Submission link http://majorprojects.planning.nsw.gov.au/index.pl?action=view_job&job_id=9579

**Concept State Significant Development Application – SSD 18_9579 Crows Nest Overstation
Development - Submission**

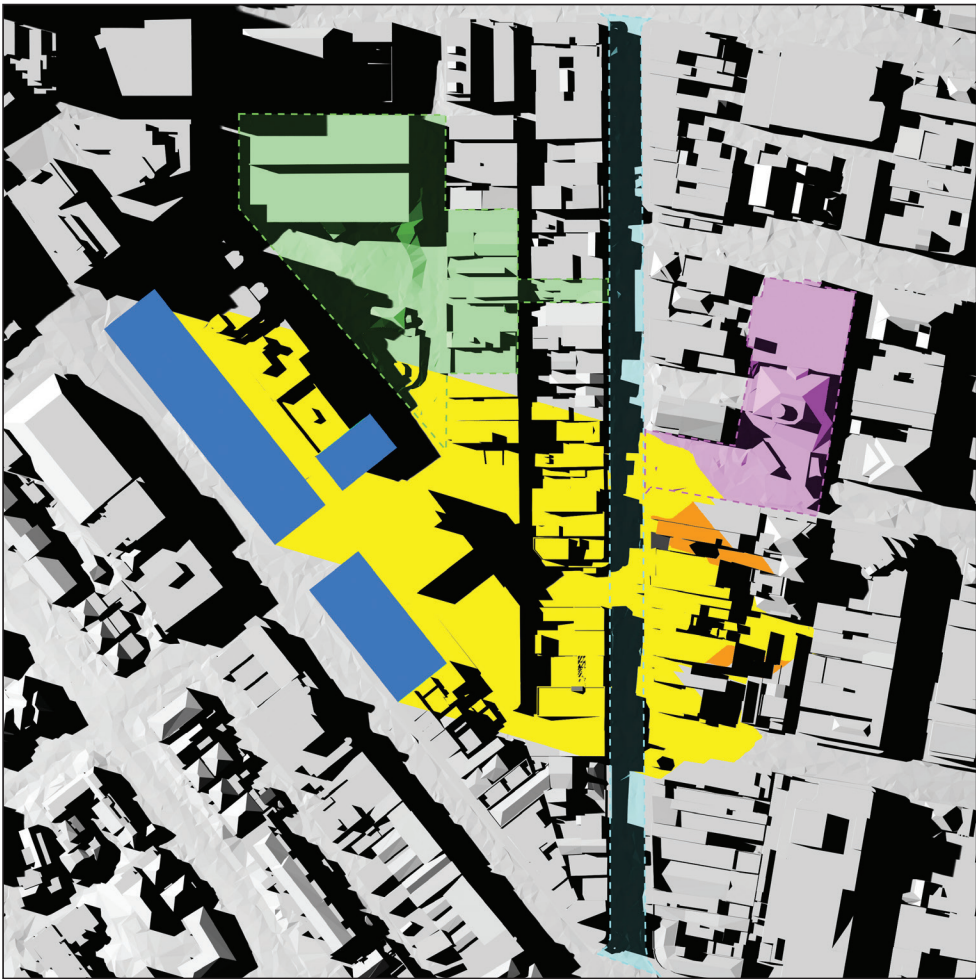
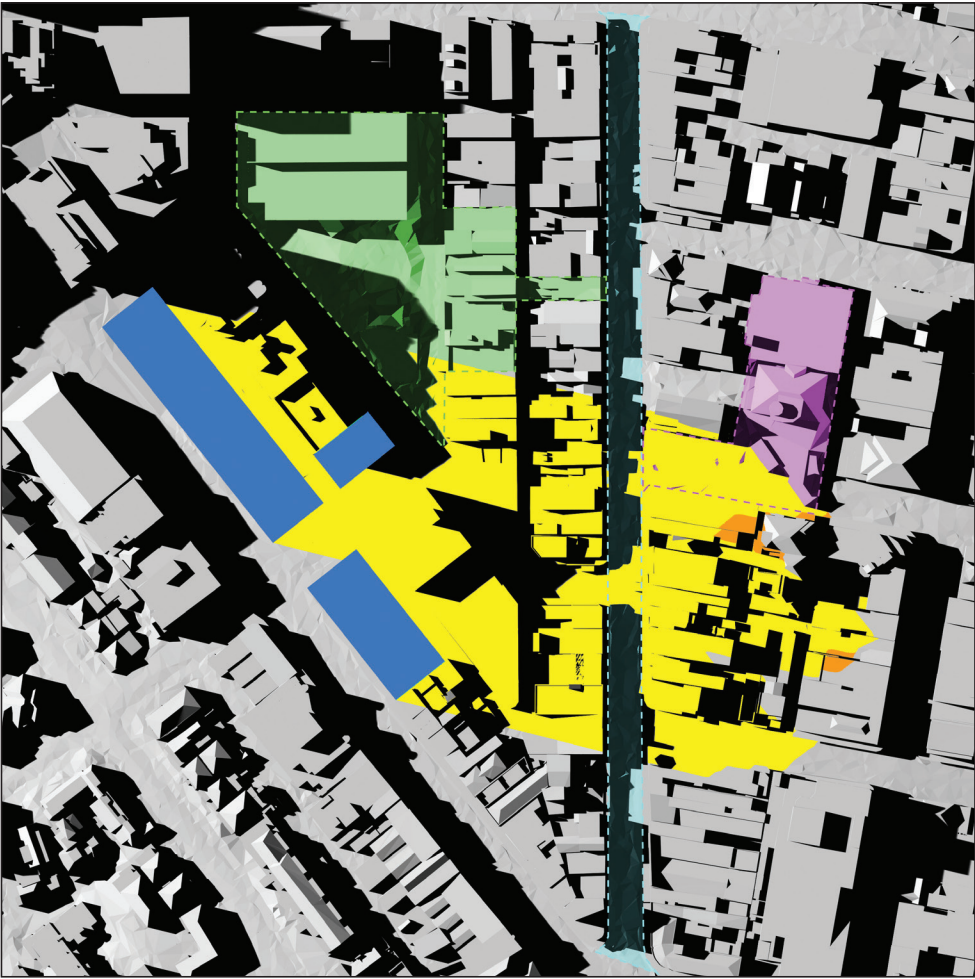
- I object to the overshadowing of Nicholson Street, Hume Street Park, Willoughby Road and Ernest Place in particular year-round, not just between 9.00 am and 3.00 pm.
